MEADOWBANK TAFE – MULTI STOREY CAR PARK EXTENSION L3 & 4

CONCEPT REPORT

OCTOBER 2021

Report prepared for	Hansen & Yuncken Sydney Corporate Park Building 1, L3, 75-85 O’Riordan Street Alexandria NSW 2015 Attention: Sasha Vuckovic
Report prepared by	Metro Building Consultancy Suite 102, 12 Mount Street North Sydney NSW 2060 Consultant: Sean Moore
Report reference	19209-MSCP EXT R01
Job number	19209
Date	04 th October 2021

DWG #	DA103	REV	B
SCALE @ A1	1:200

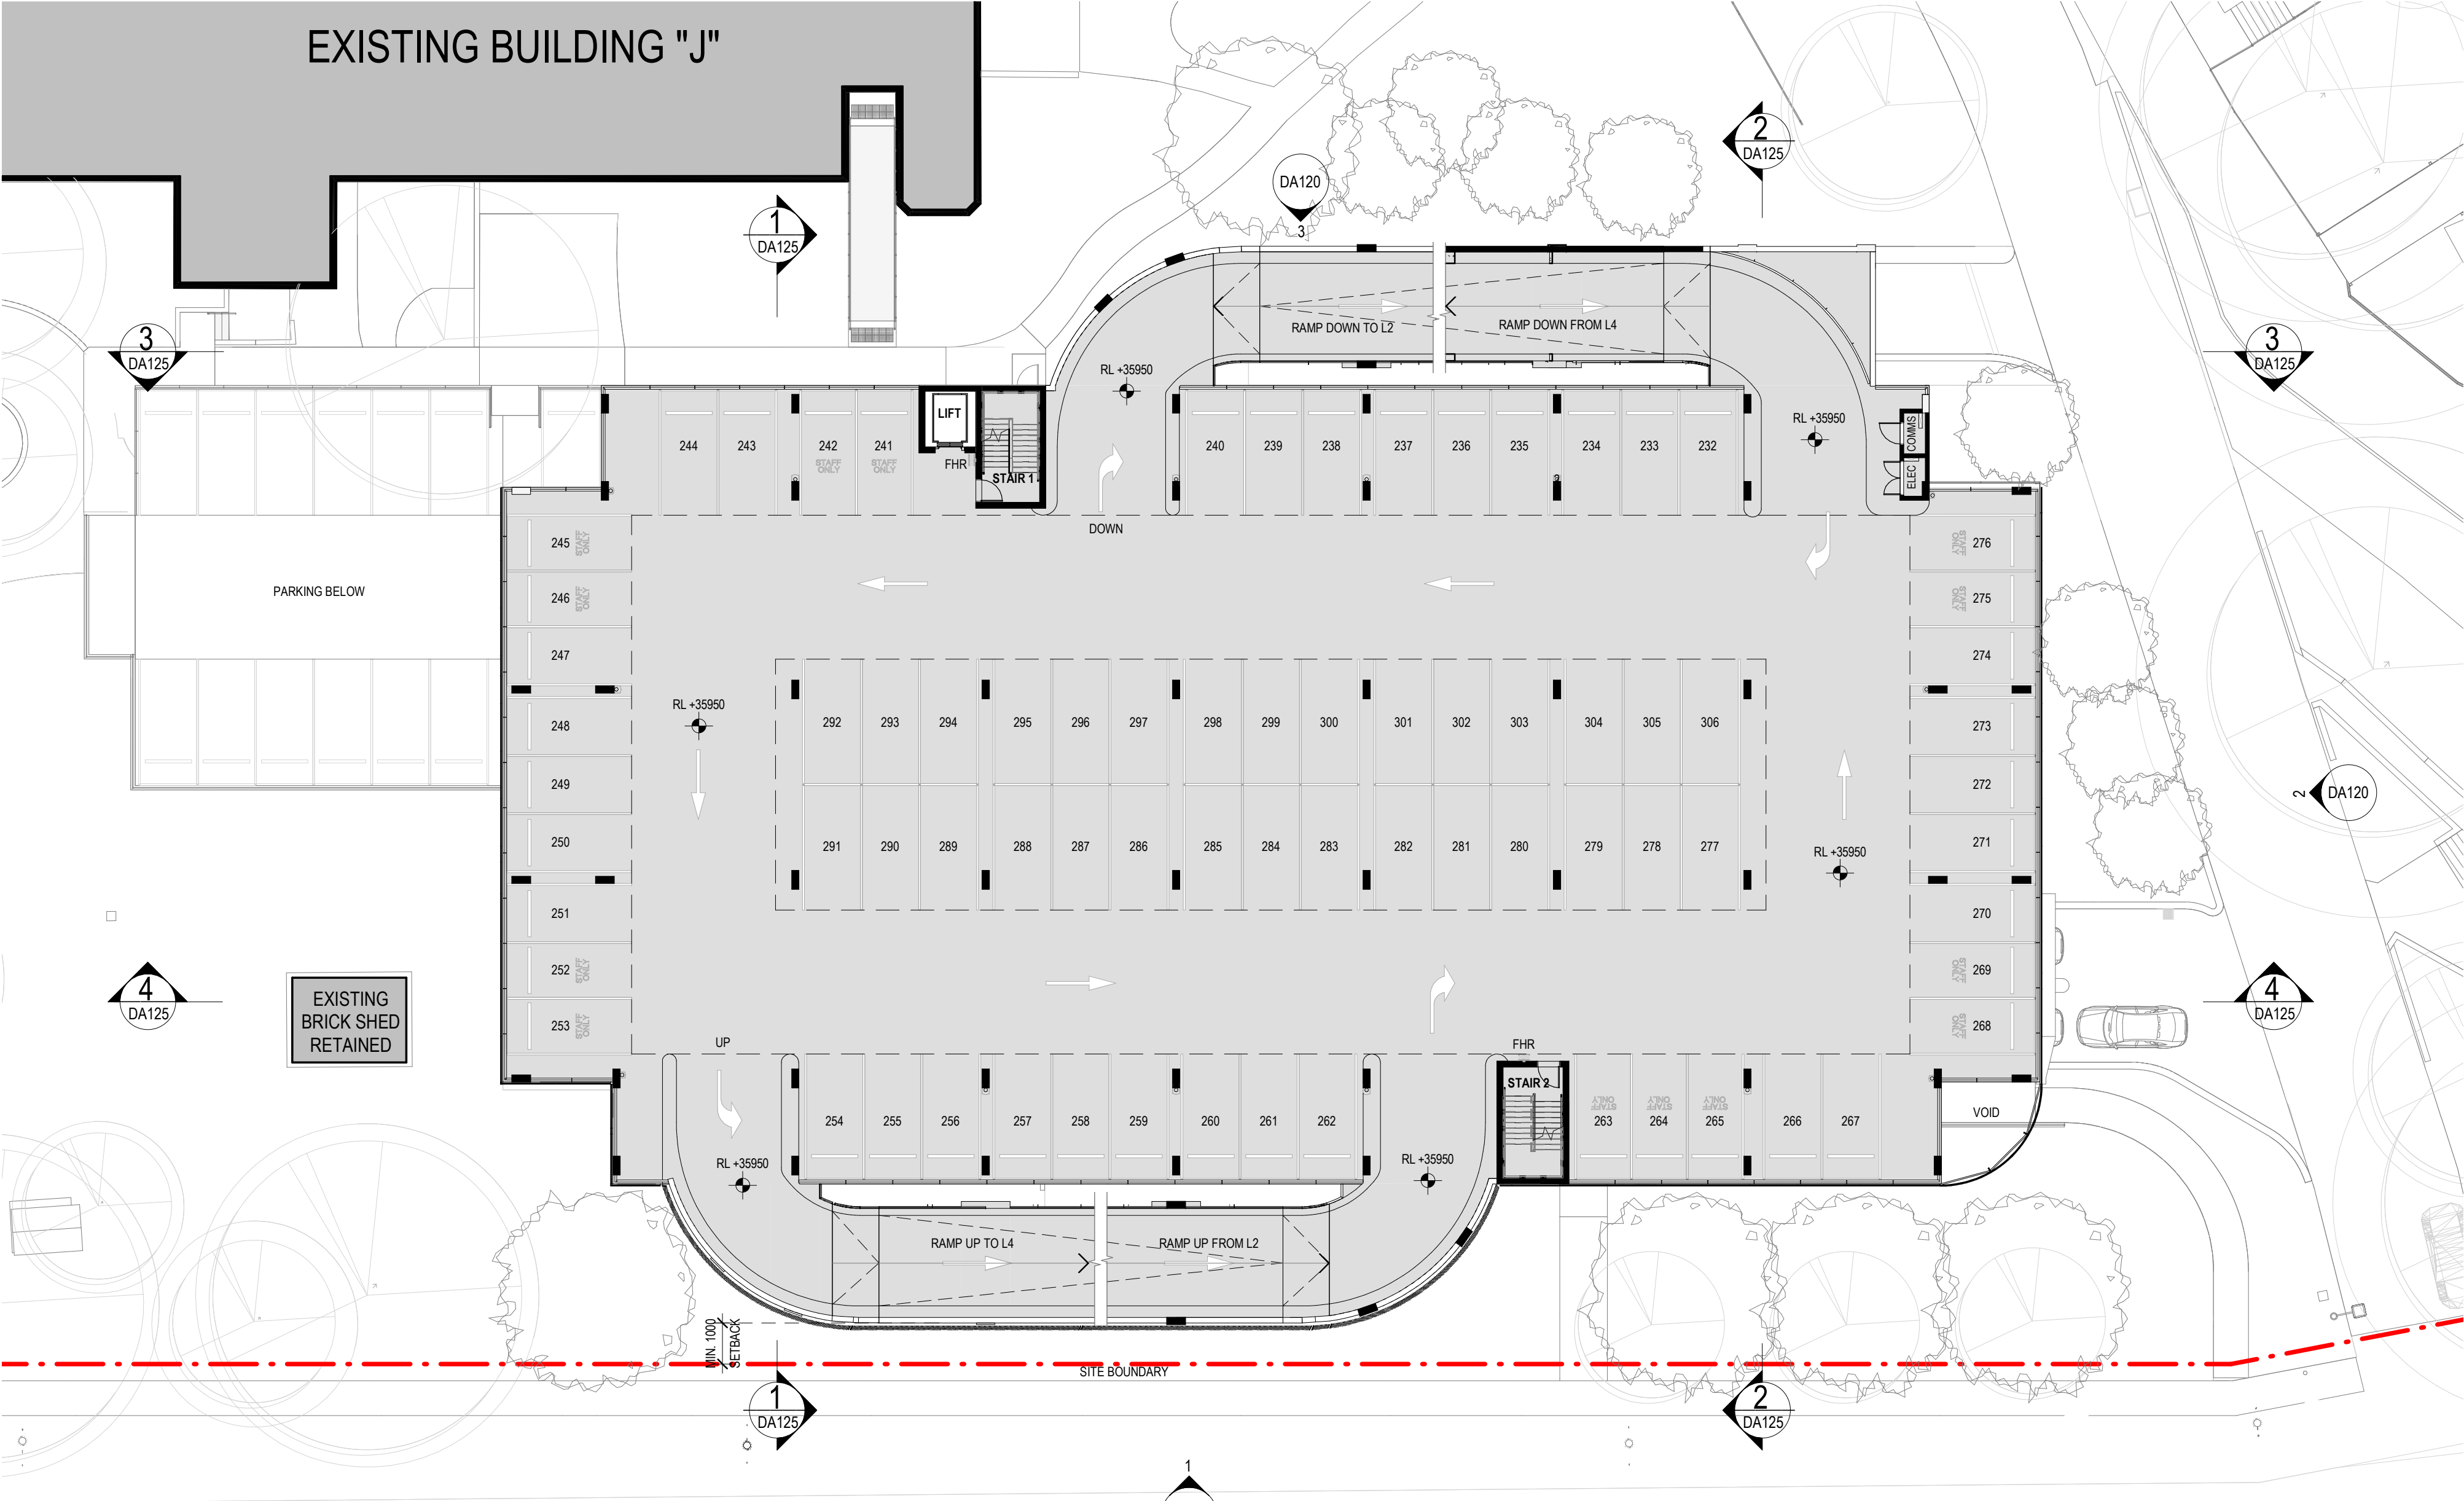
The drawings provided do not show the fire rating level of the walls of the lift. Please ensure that an FRL of 120/120/120 is achieved for the walls of the lift shaft and a note stating the fire rating level is added to the updated plans.

In addition, it should be noted that the top of this fire rated lift shaft is required to have an FRL of 120/120/120.

DWG #	DA120	REV	D
SCALE @ A1	As indicated

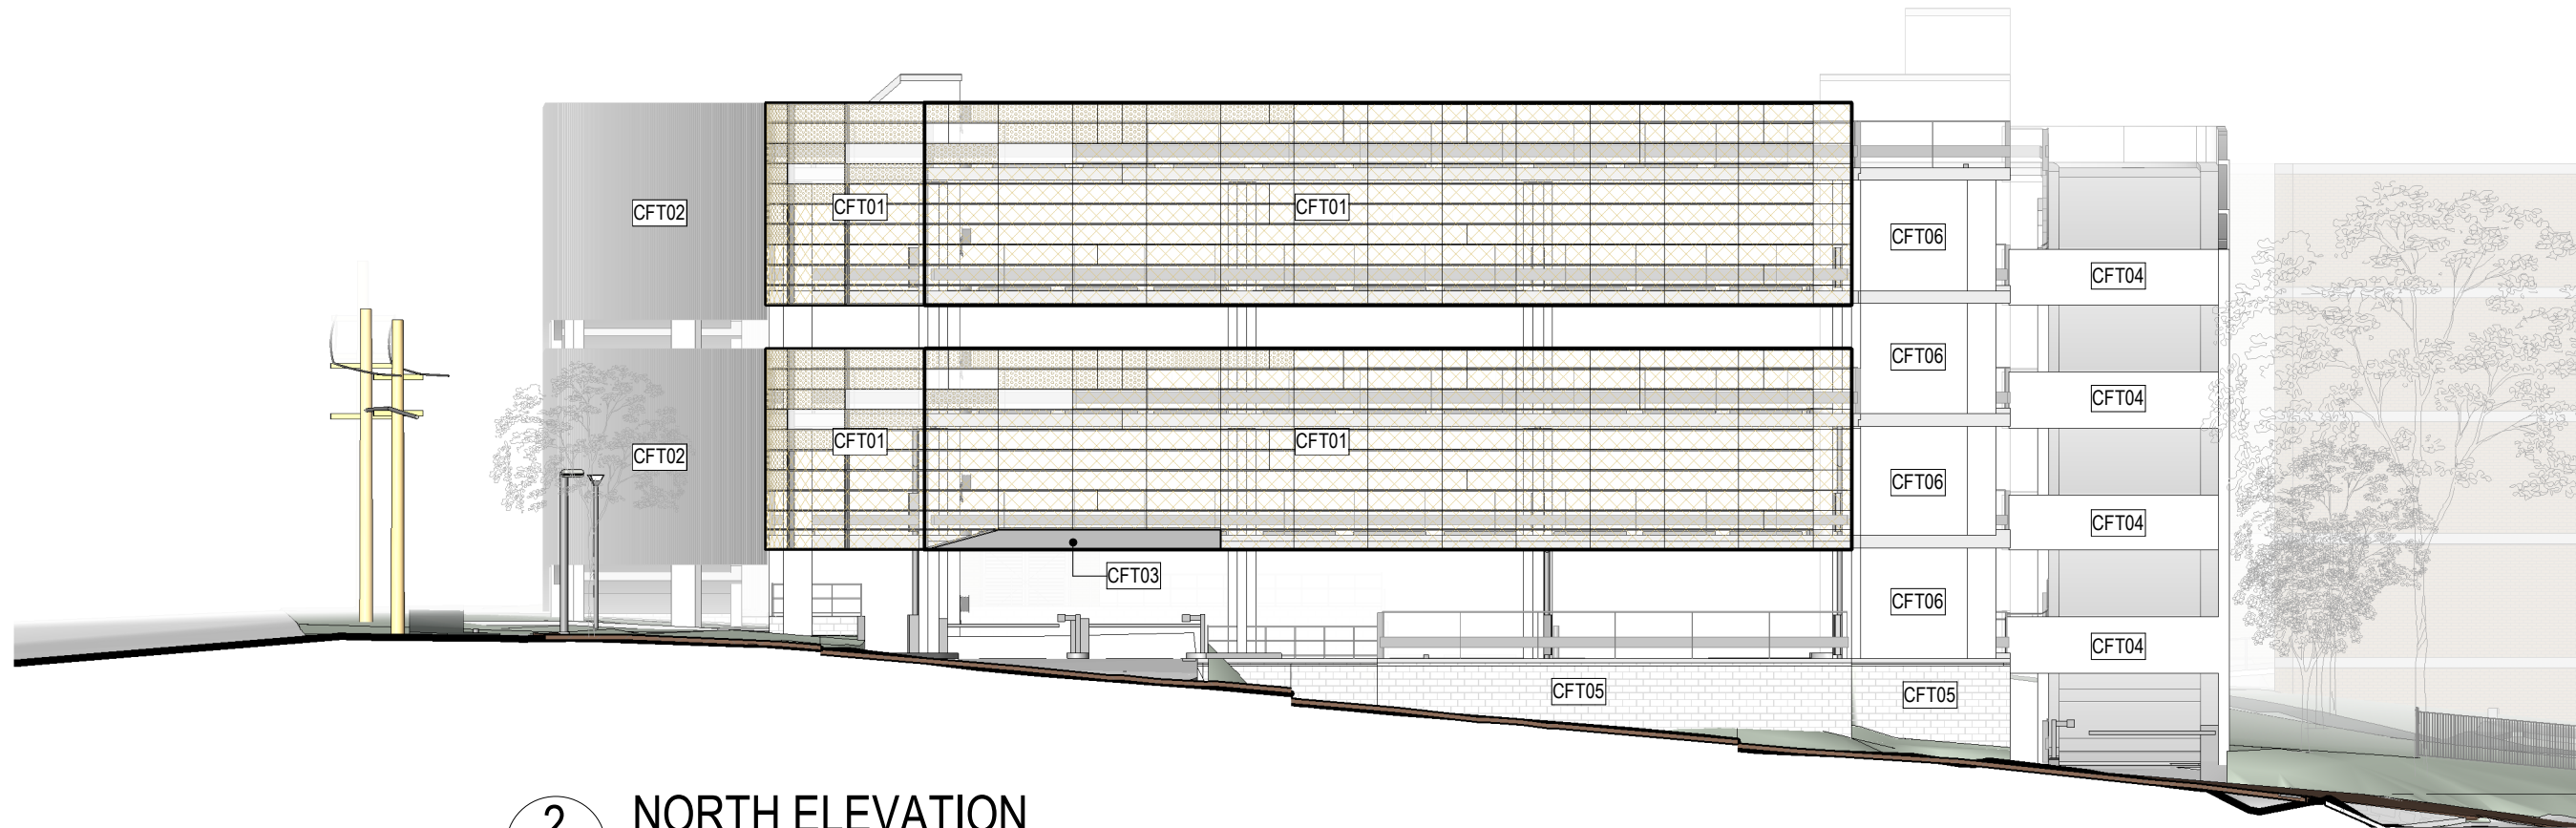
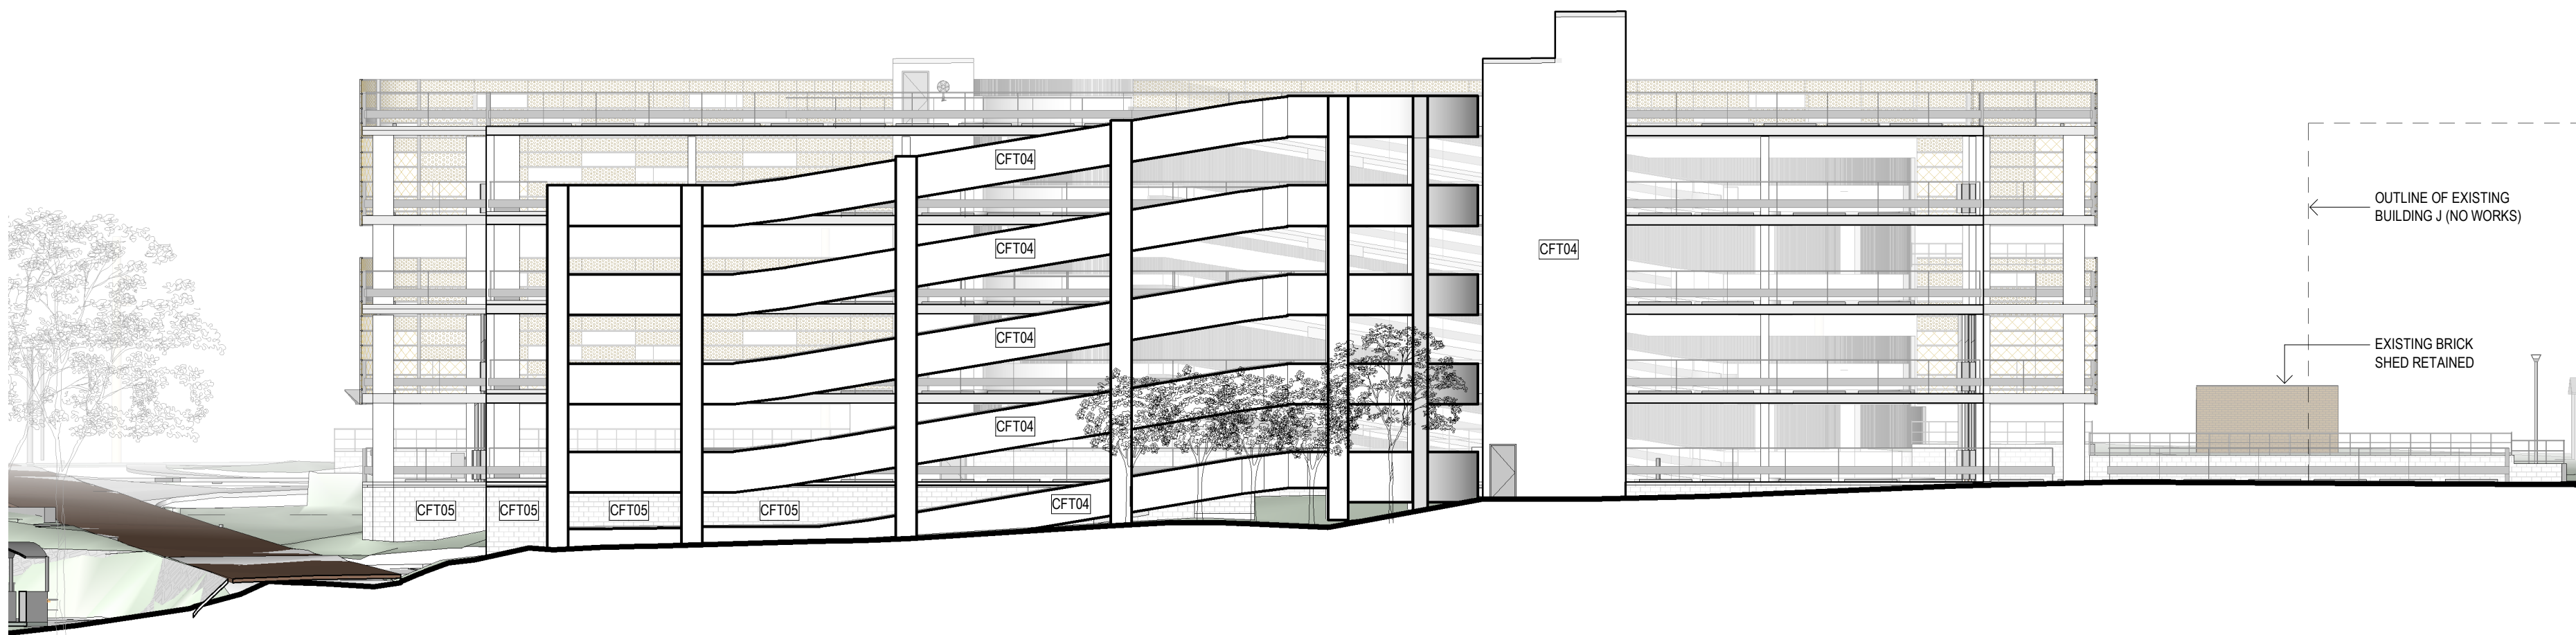
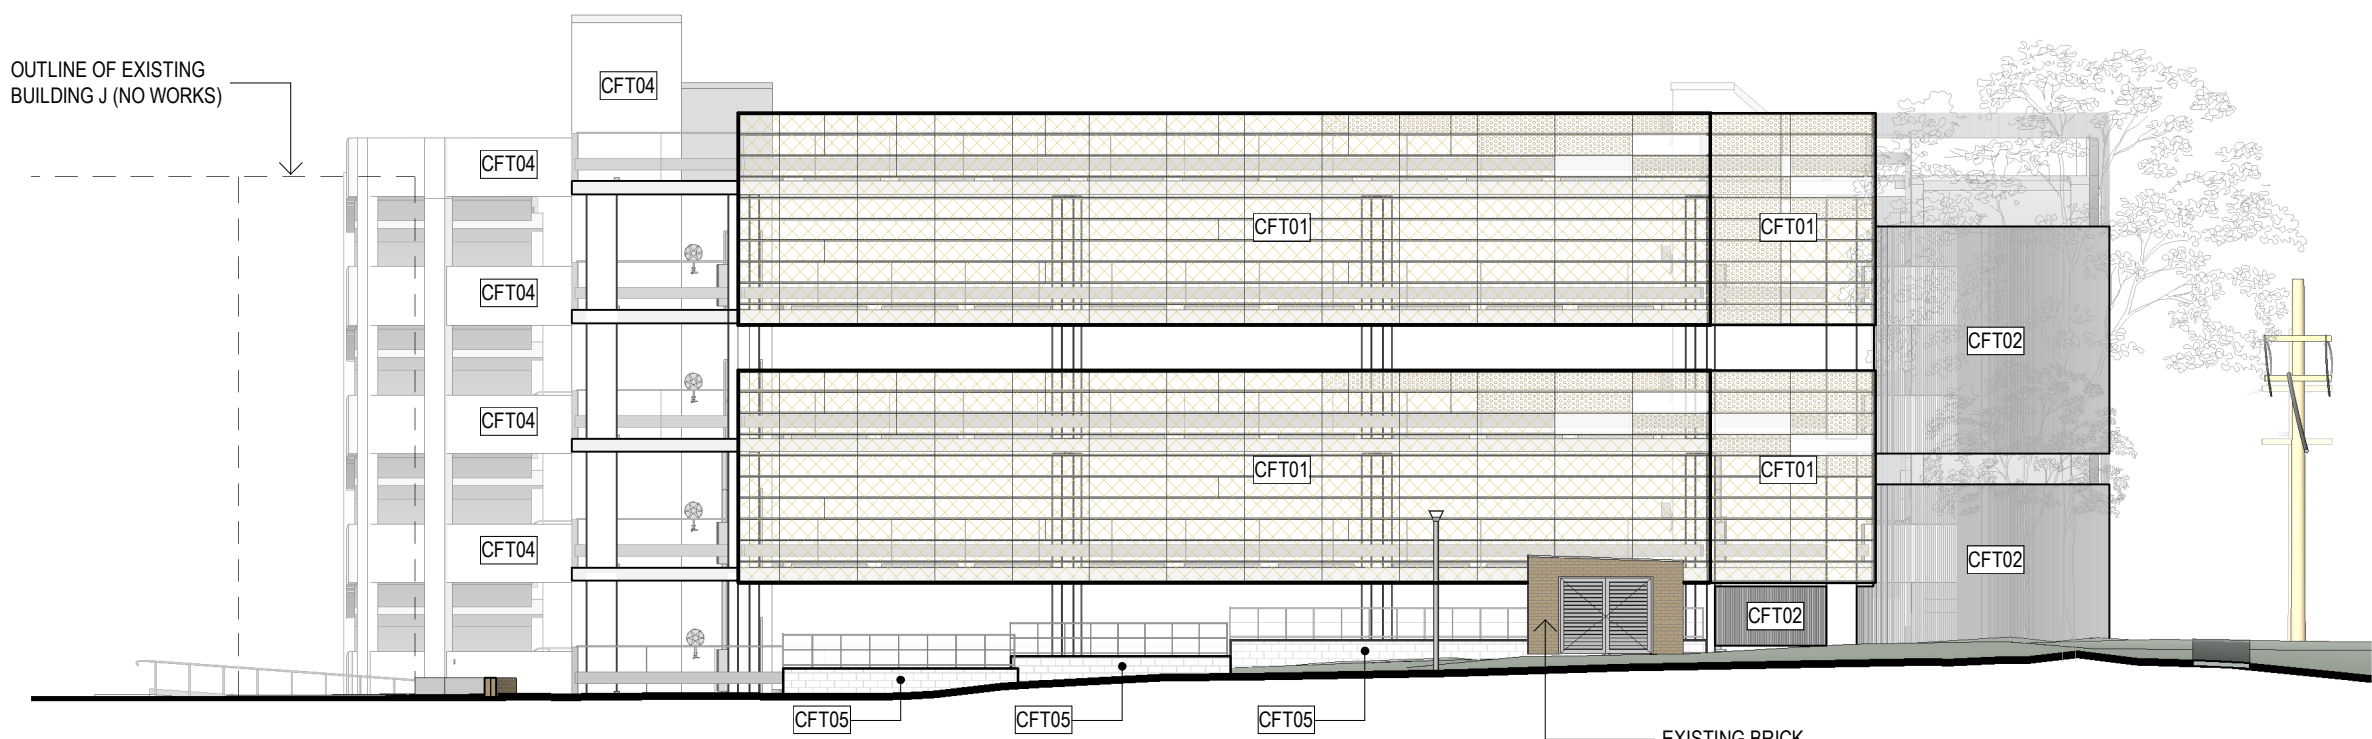
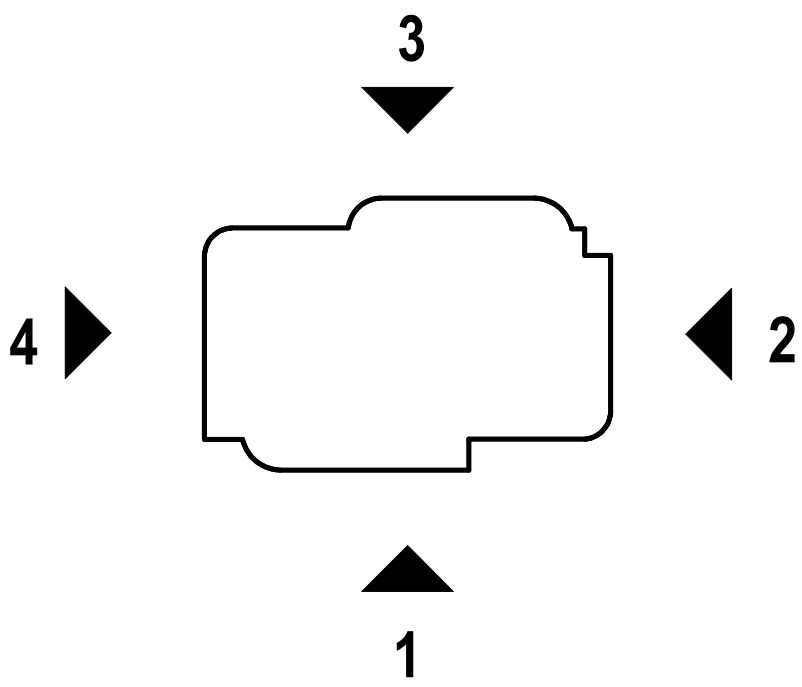
Provide details of the external wall construction for review.

The Building Code of Australia 2019 Amendment 1 does not place a maximum fire compartment size for open deck carpark. Provide details of the cladding to the sides of the building and confirmation that it will permit the building to comply with the BCA open deck carpark requirements below.

Provide details of the cladding to the sides of the building and confirmation that it will permit the building to comply with the BCA open deck carpark requirements below.
